Ref: SSD-79261463

**RE: SUBMISSION TO SSD-79261463 FOR RESIDENTIAL FLAT BUILDING WITH INFILL
AFFORDABLE HOUSING AT 2-4 WOODSIDE AVENUE & 1-3 REID STREET, LINDFIELD**

Ku-ring-gai Council's objection to SSD-79261463 at 2-4 Woodside Avenue & 1-3 Reid Street, Lindfield

COMMUNAL OPEN SPACE

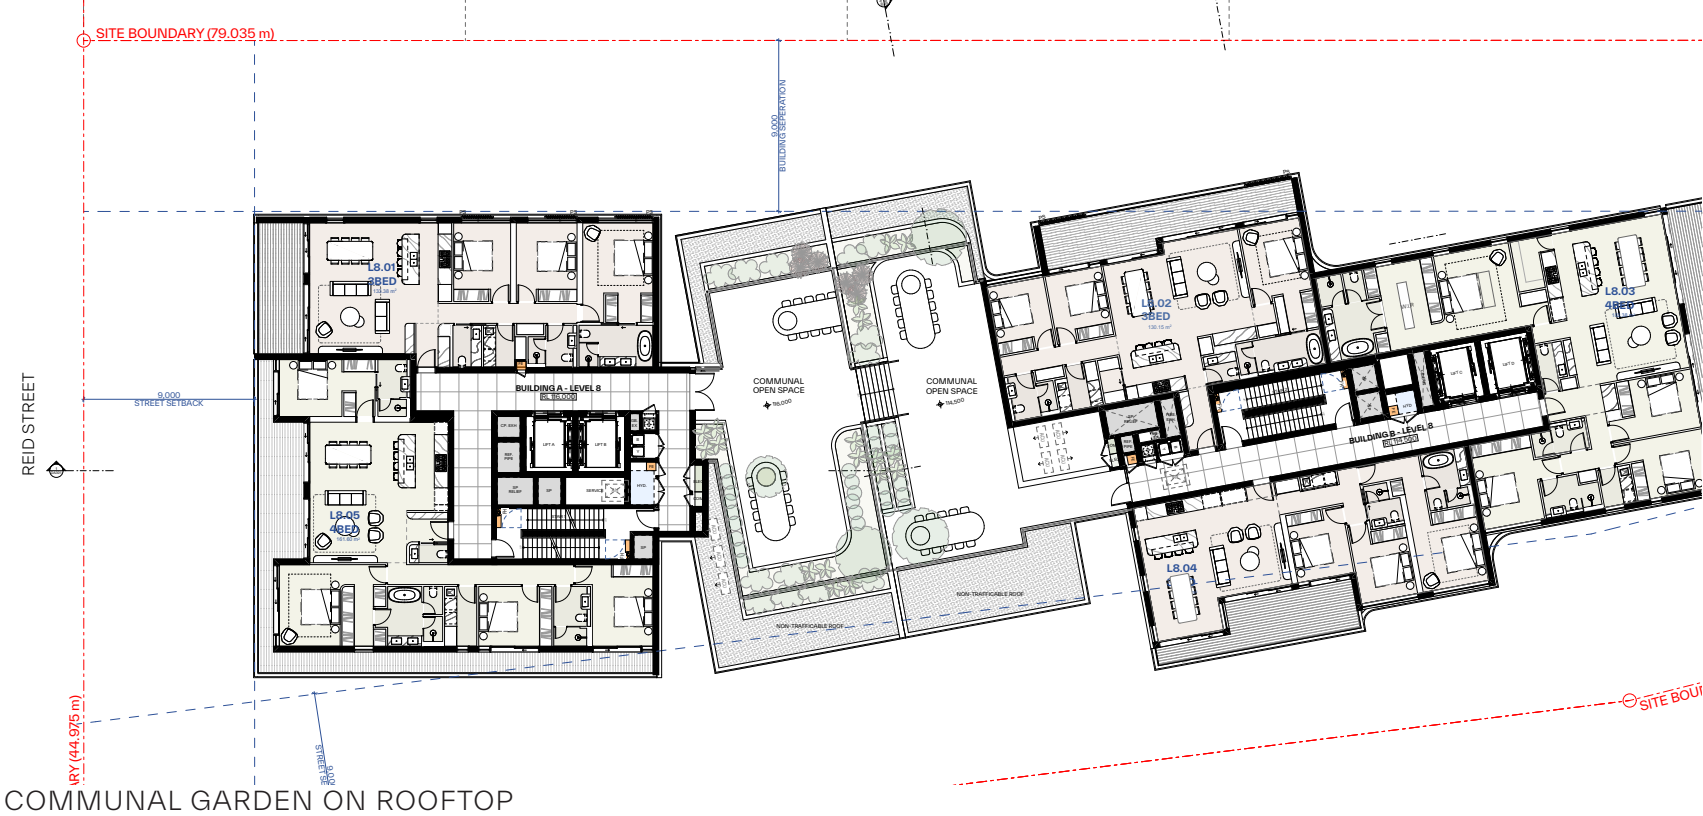
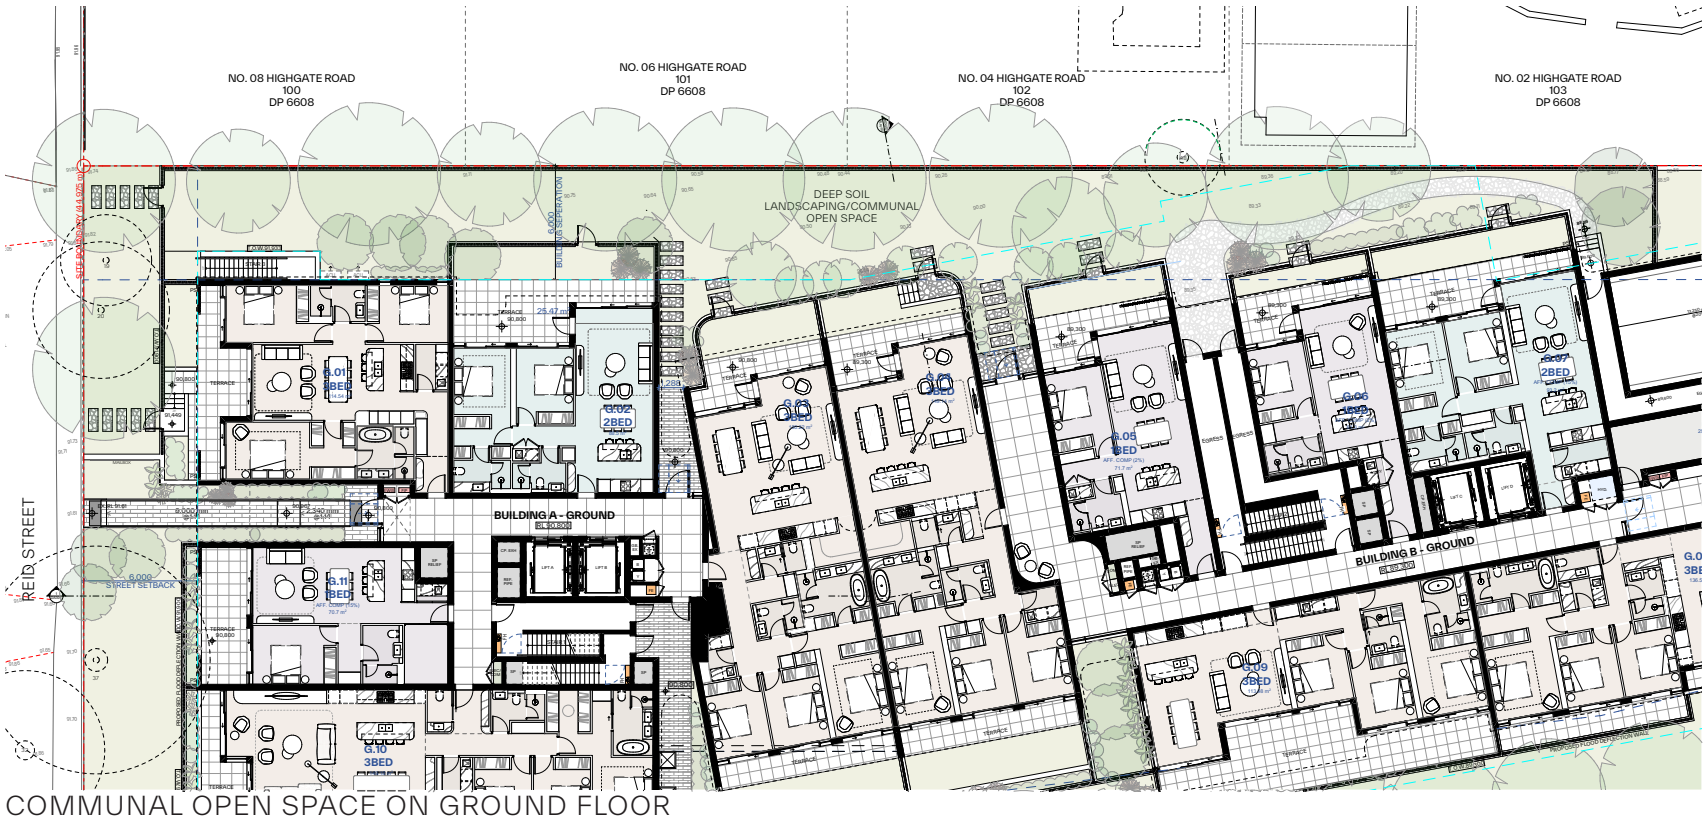
Planting is proposed above basements, OSD tanks, and roof terraces (e.g., Level 8 COS), but the landscape and architectural plans do not provide necessary details on soil depths, volumes, or wall heights. Without this information, compliance with ADG requirements cannot be verified.

Figure 6: A 3D model of the development as viewed from the east, showing proposed elements that do not comply with the 28.6 metre building height overlay (denoted by the pink overlay)

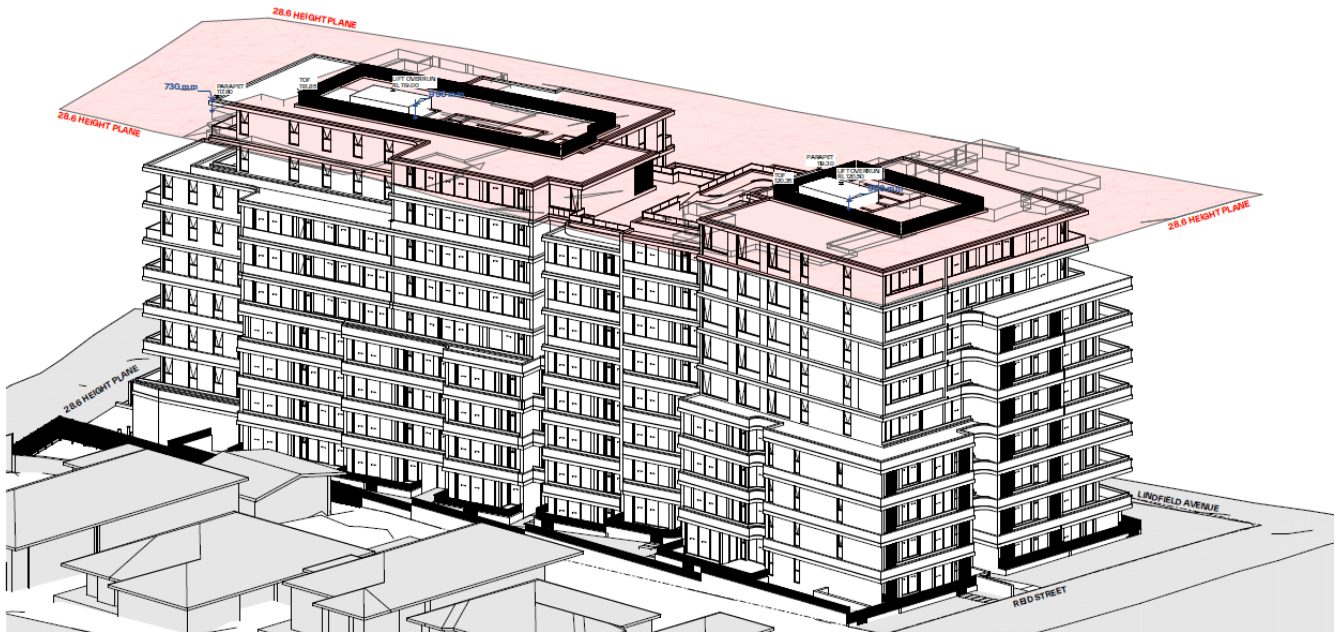
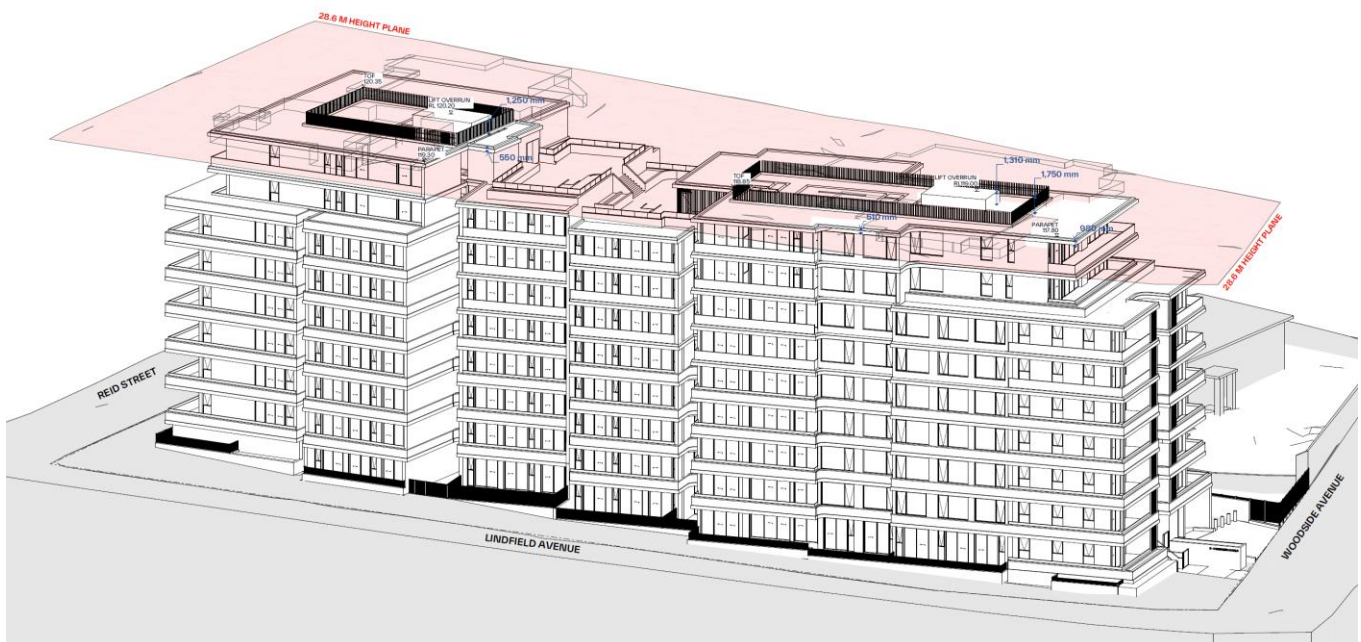
- *The elements of the proposed development that exceed the building height standard include the lift overruns, rooftop plant equipment, and the upper-most sections of the walls on Level 9. Importantly, no rooftop common areas are proposed, meaning there will be no opportunities for additional overlooking from shared spaces. In terms of visual privacy, the site benefits from separation on three sides due to the surrounding road network, which provides effective screening and ensures there is no adverse impact on adjoining developments in those directions, regardless of the minor height exceedances. The only potential interface for visual privacy consideration is to the south, where no development application has yet been lodged. Any future development on that adjoining land will be required to manage privacy impacts through its own design response in accordance with applicable planning controls*

Furthermore, part of the building which breaches the height of building standard does not comply with the required building separation setback specified in the ADG.

STORMWATER MANAGEMENT PLAN
SCALE - 1:150/A1, 1:300/A3

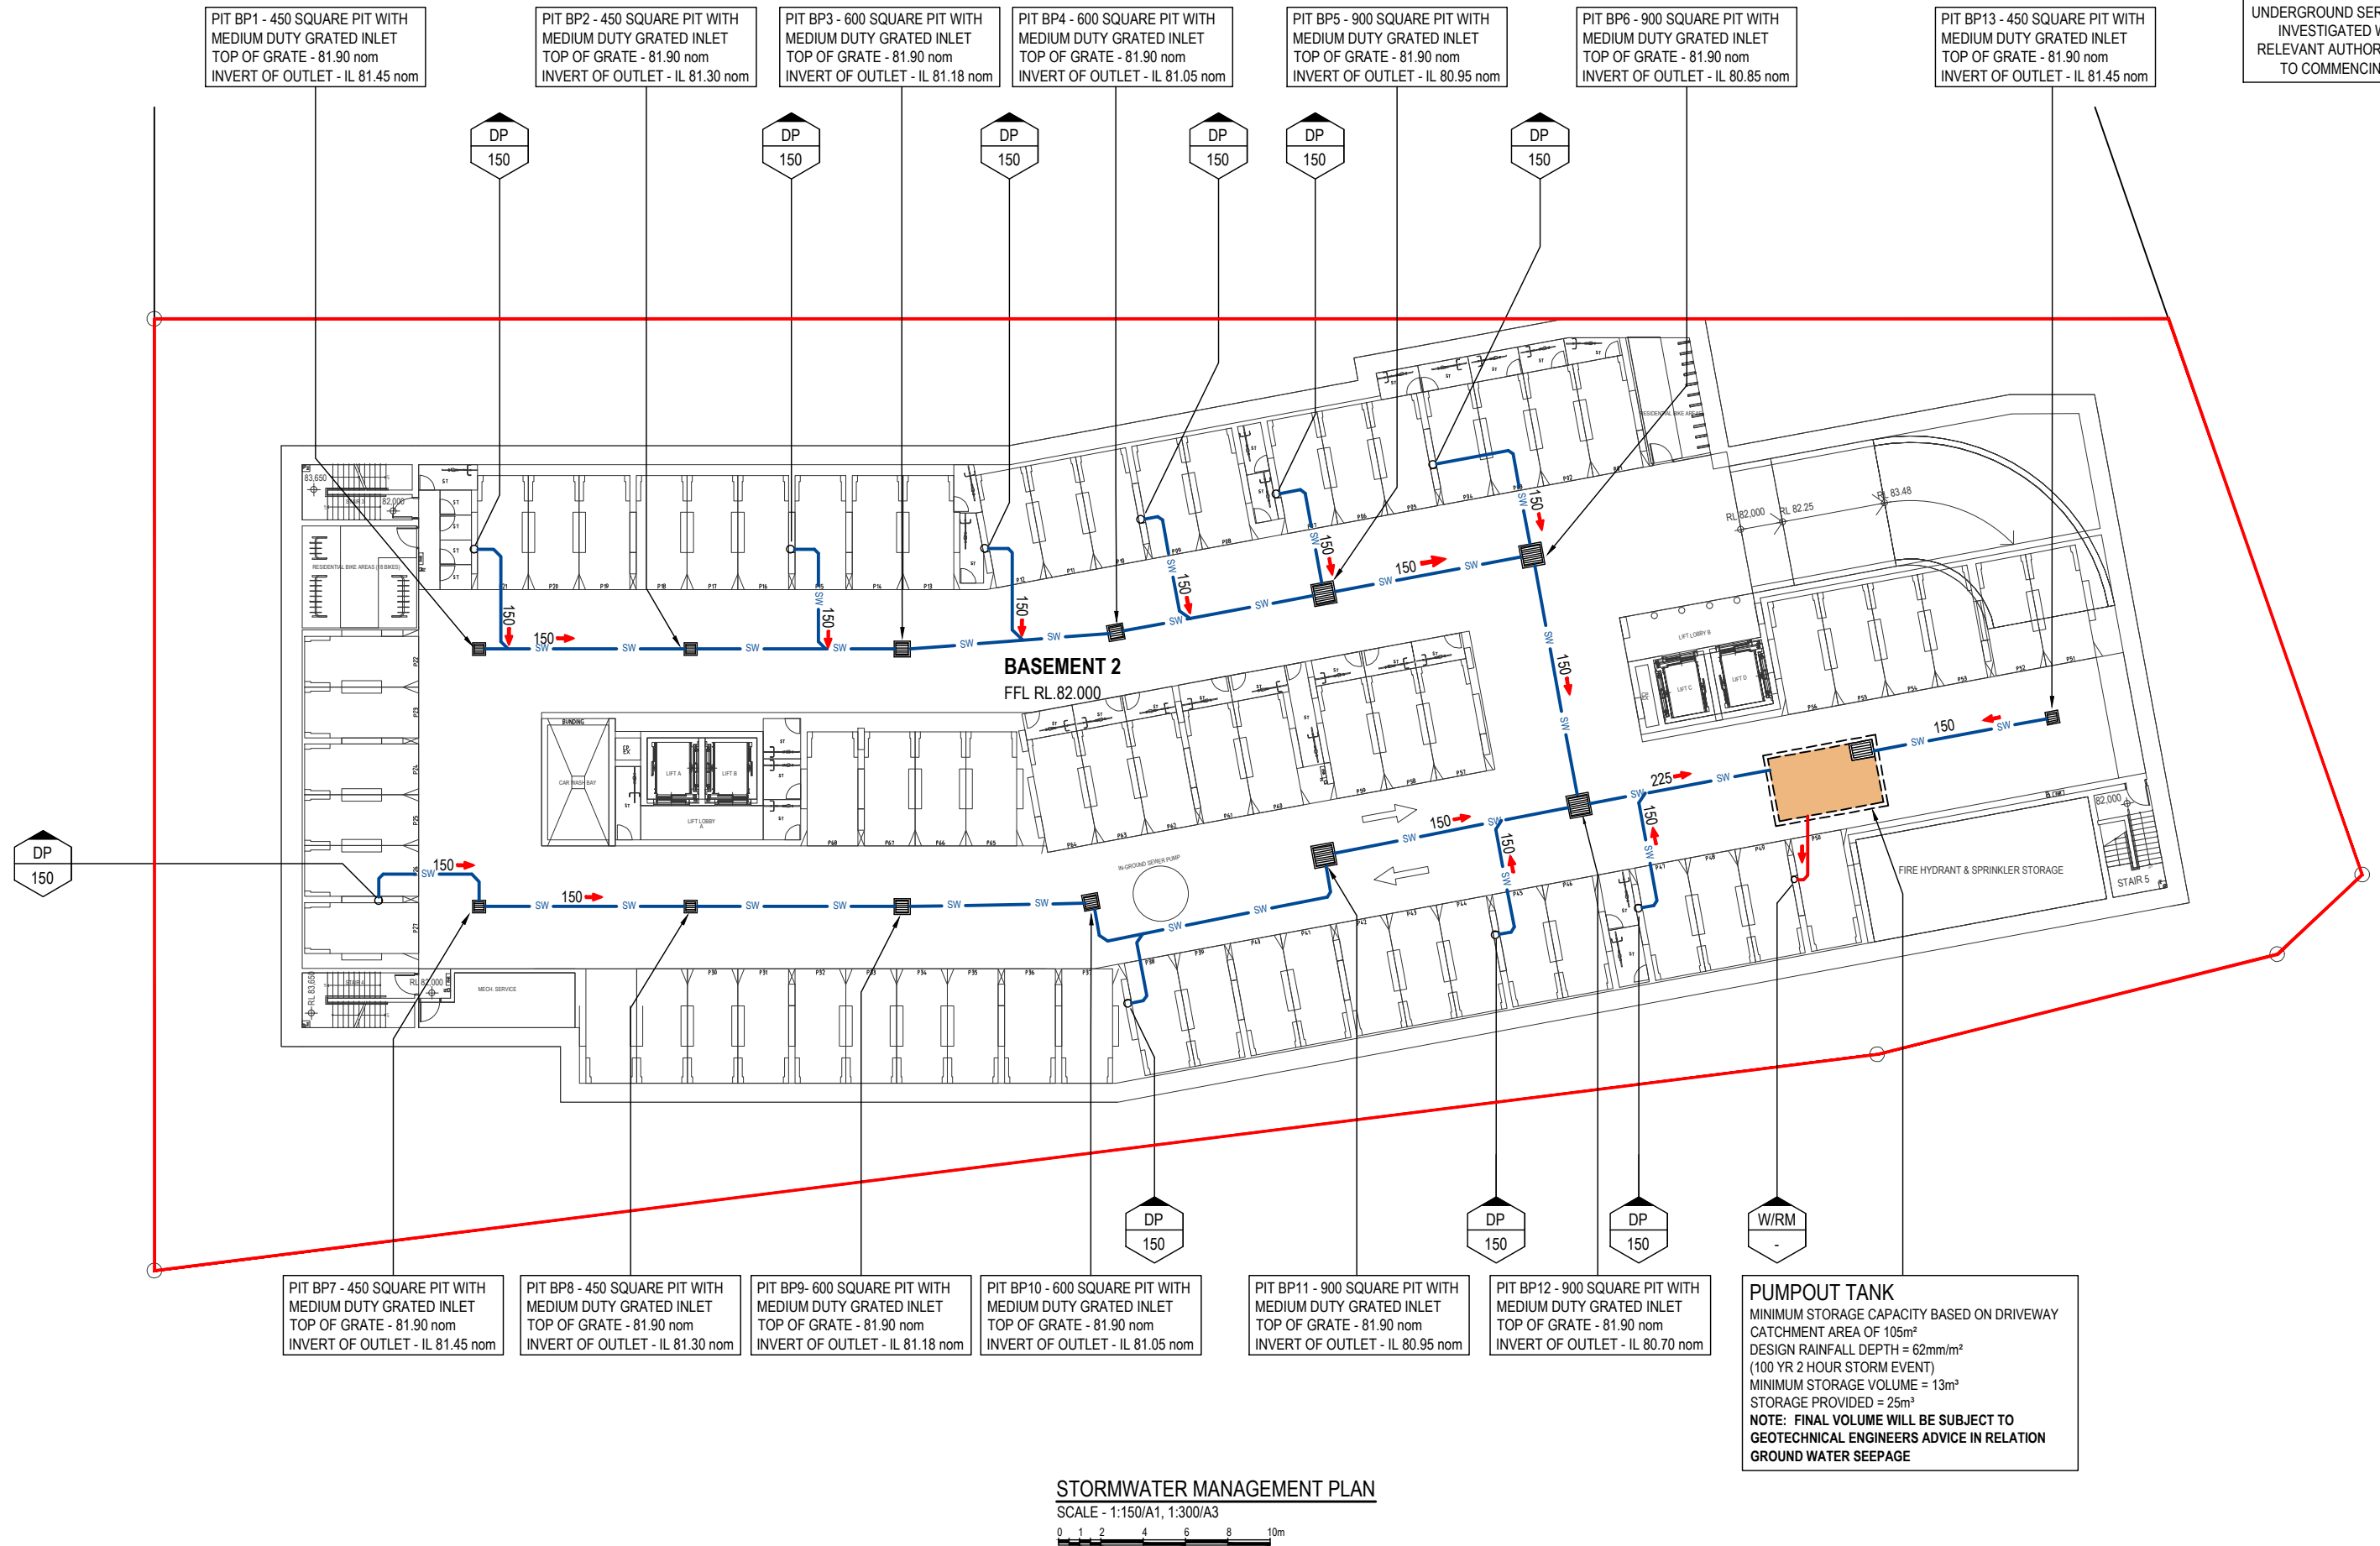
Deep soil areas along side setbacks are restricted by basement and stormwater structures and cannot accommodate large or medium trees. Key local trees such as T38 and T28 are not retained. While the proposal indicates retention of T28 (a remnant of the STIF ecological community), this is not agreed due to structures within its Structural Root Zone.

- T27 (*Melaleuca quinquenervia*) and T28 (*Syncarpia glomulifera*): Proposed as retained, but basement and stormwater works compromise their Tree Protection Zones (TPZs) and Structural Root Zones (SRZs). Retention is not feasible under current design. T28, is part of a Critically Endangered Ecological Community- Sydney Turpentine Ironbark Forest (STIF). This tree is mapped in Council's mapping system as a remnant canopy tree of the EE community STIF.

- The major impact of proposed structures on T27 and T28 is not supported. Redesign basement and stormwater infrastructure to enable retention of T27 and T28. The Arboricultural Impact Assessment (AIA) is required to be updated accordingly.
